SPR EA1N and EA2 PROJECTS

DEADLINE 9 – COMMENTS ON CAH3 SUBMISSIONS

Interested Party: SASES PINS Refs: 20024106 & 20024110

Date: 15 April 2021 Issue: 1

01/03/2021

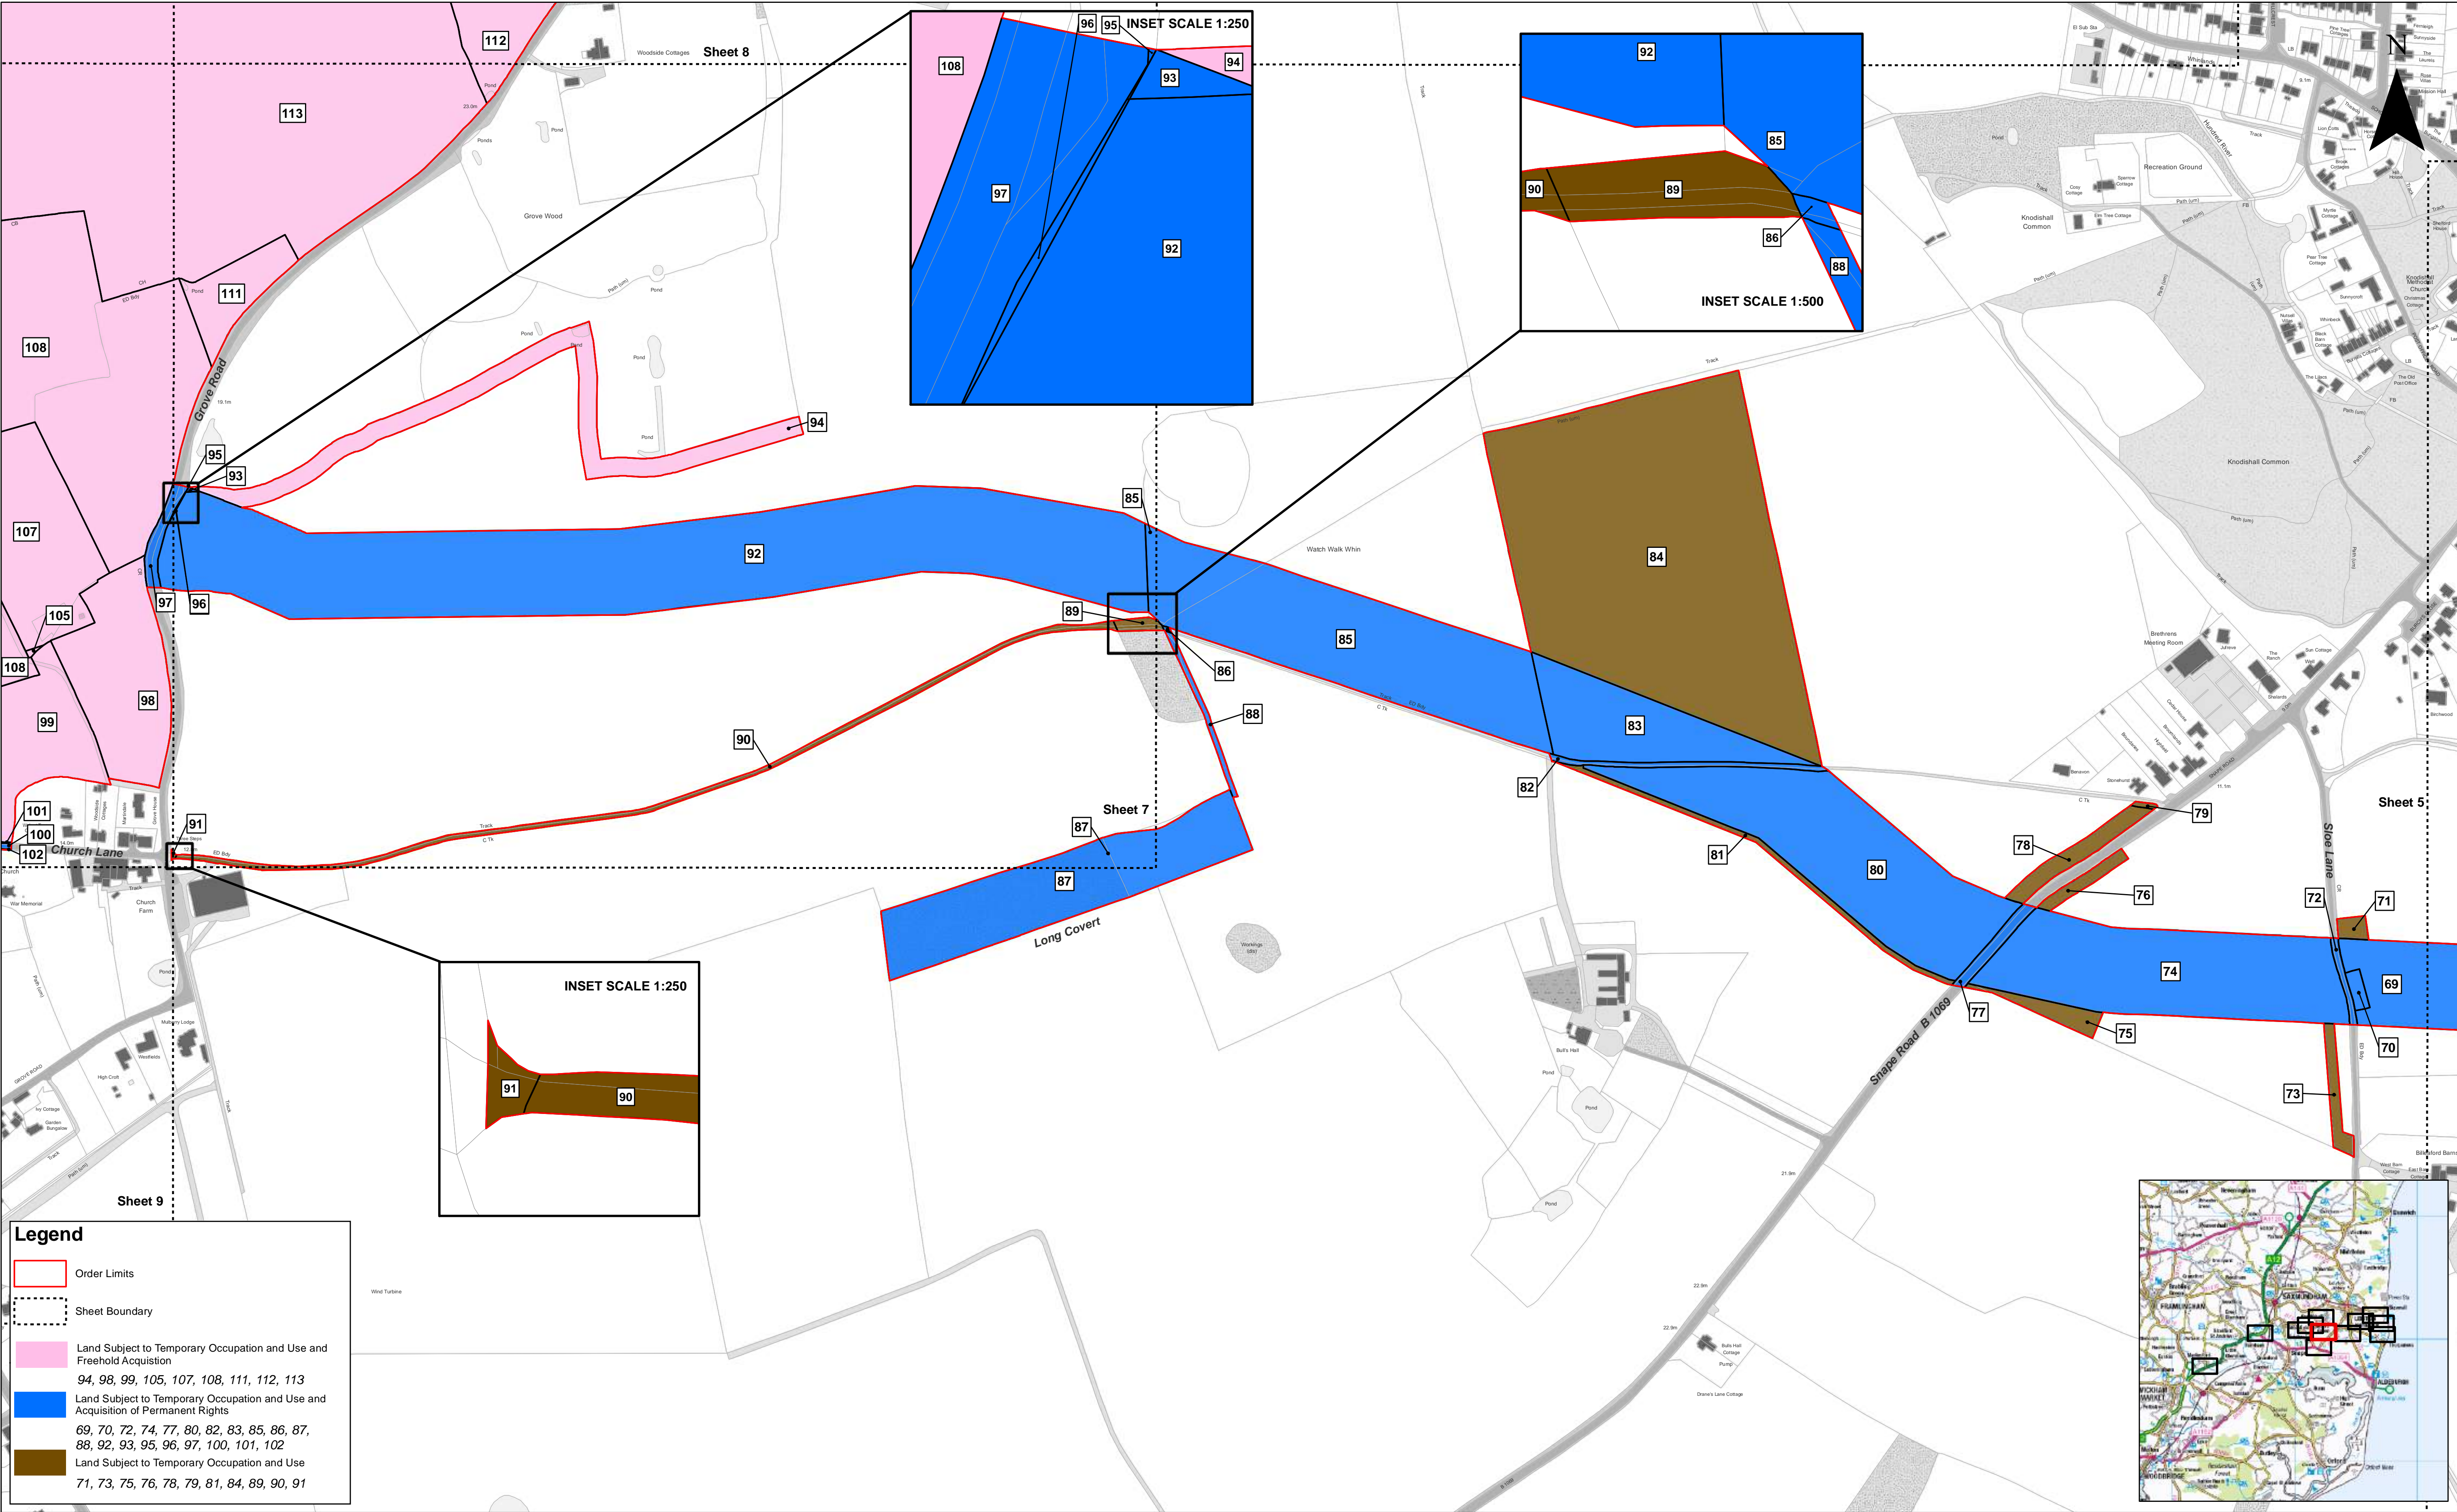
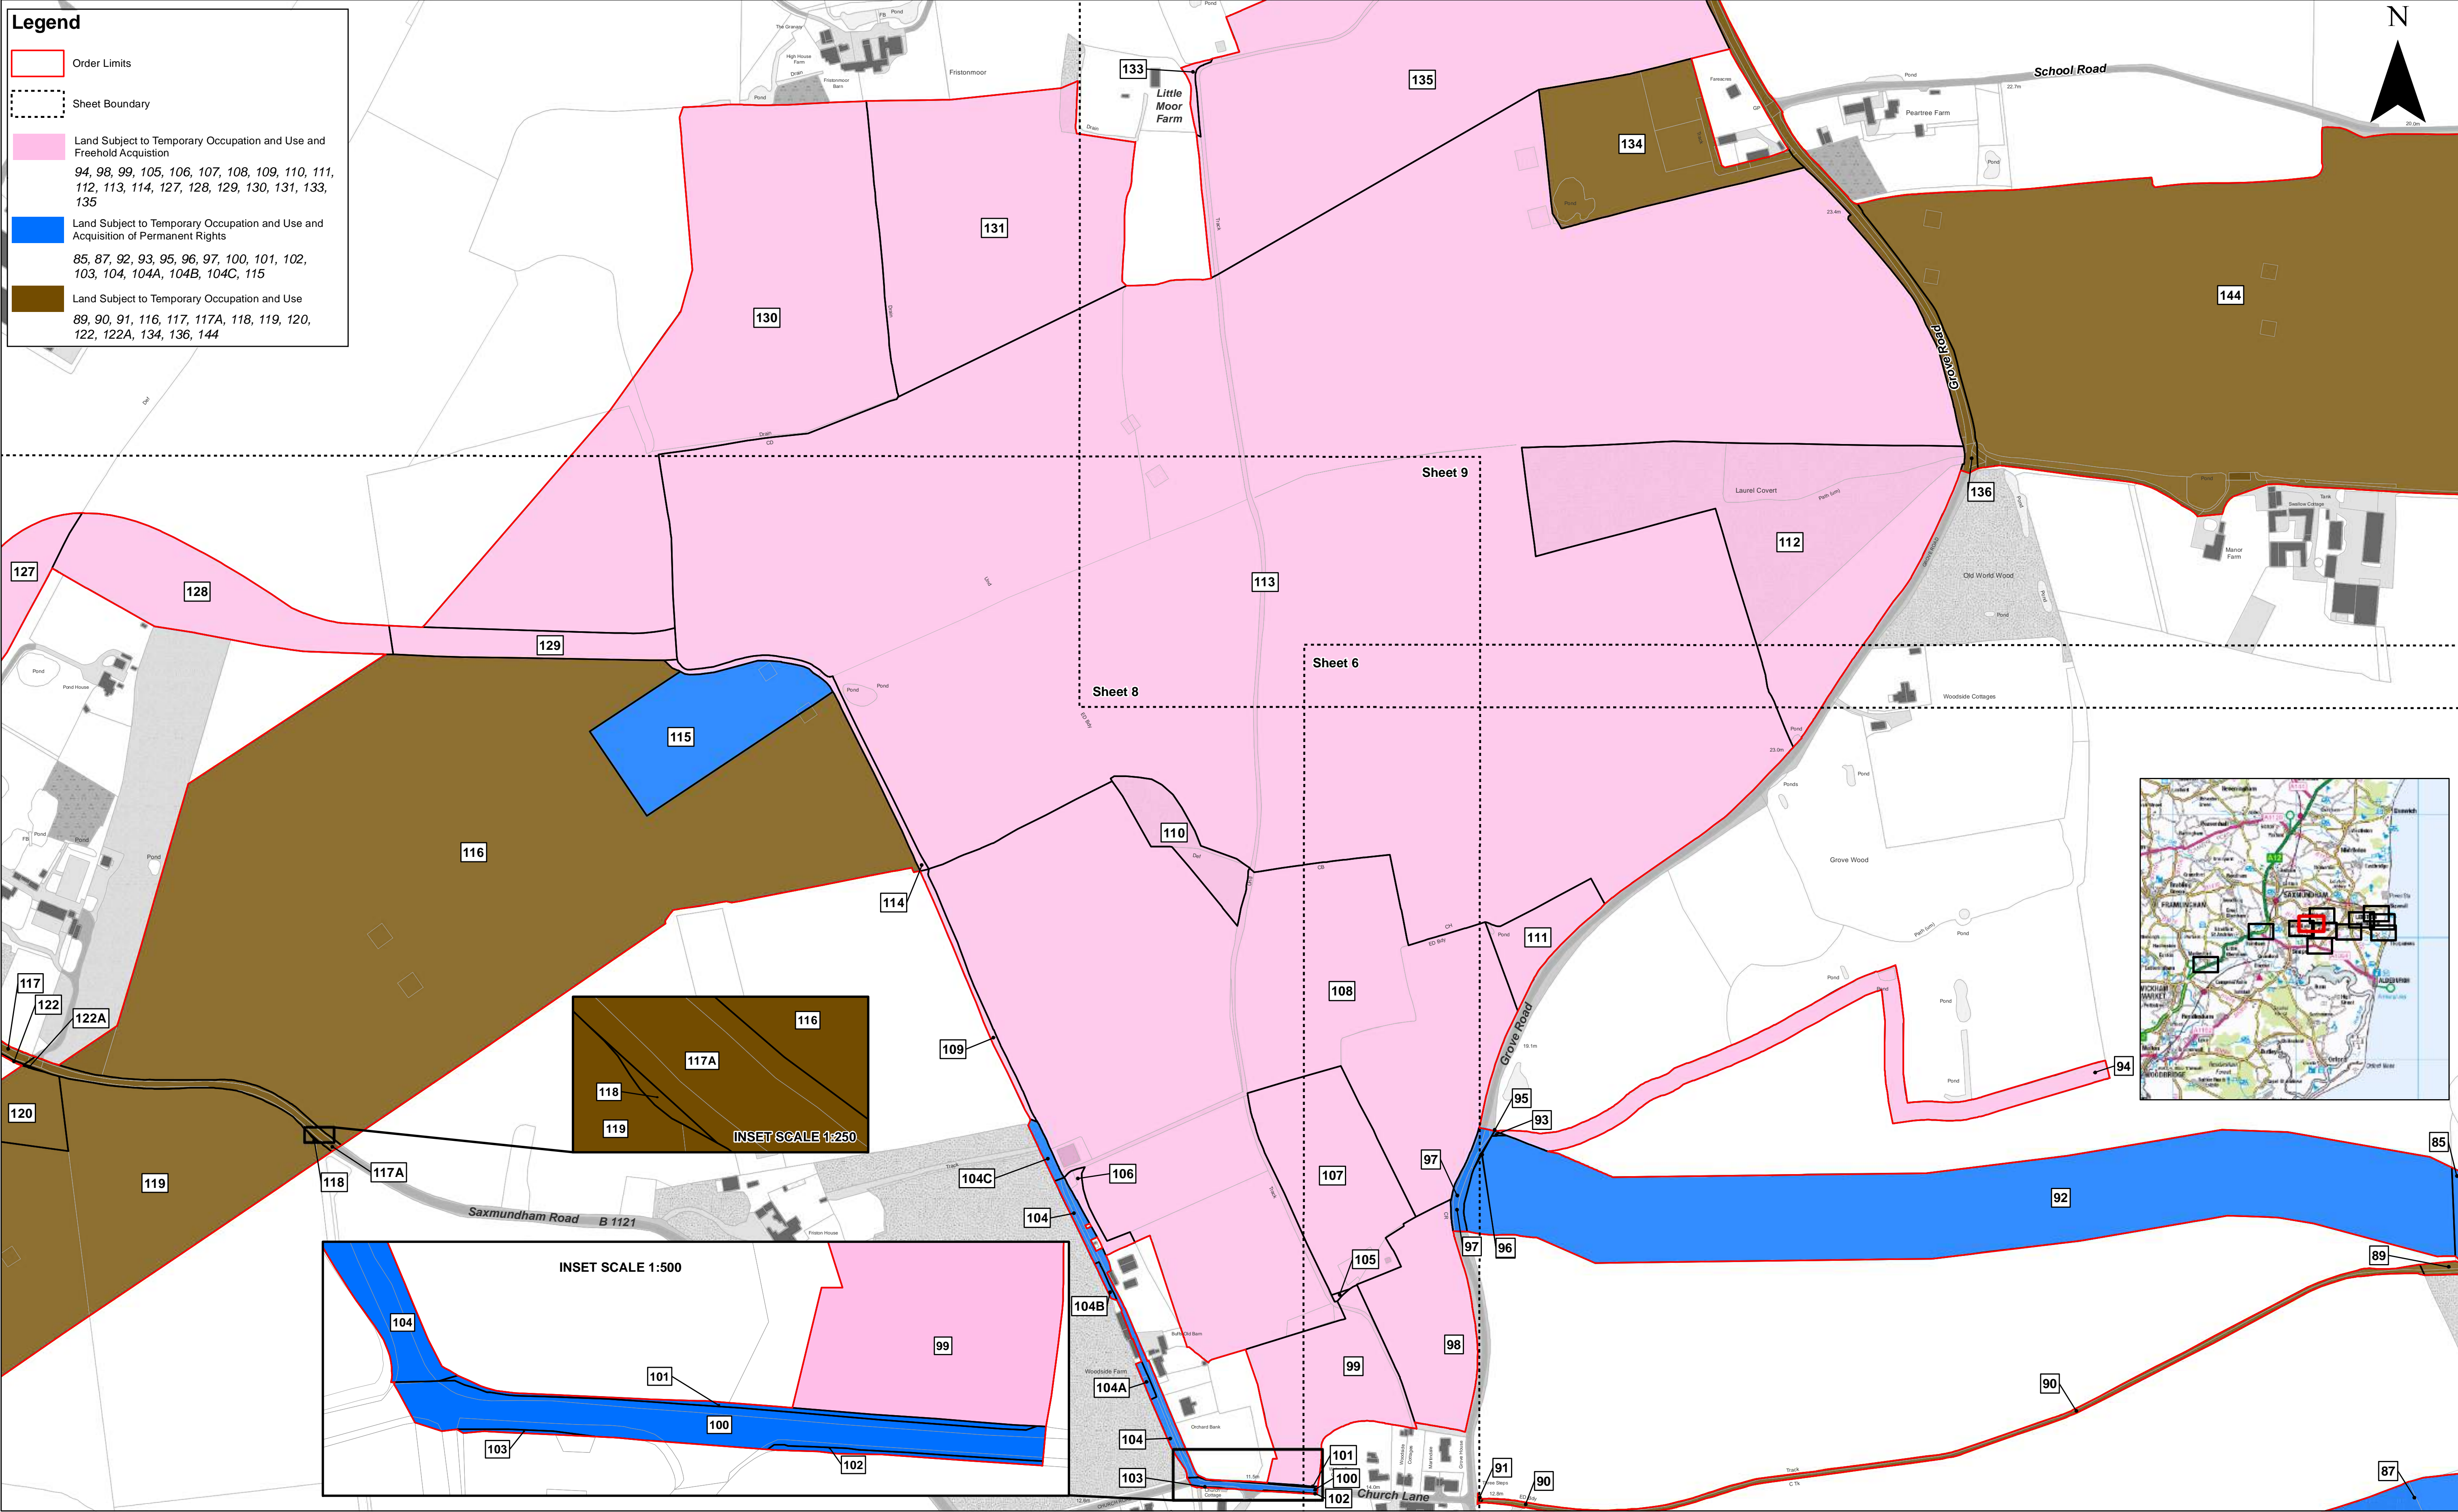
19. However, on examination of EA1N/EA2 Land Plans Rev 04, in conjunction with Suffolk Definitive Maps and Statement of public rights of way and views from Google Earth, only circa 770m of those sections of the 9.2Km cable corridor whose width is less than 75 are adjacent or even close to field boundaries. That immaterial potential saving of short 35m wide strips (at plots 13,15 and 85) cannot justify an excessive land take of 35 metres width over the remainder of the length of the cable corridors.
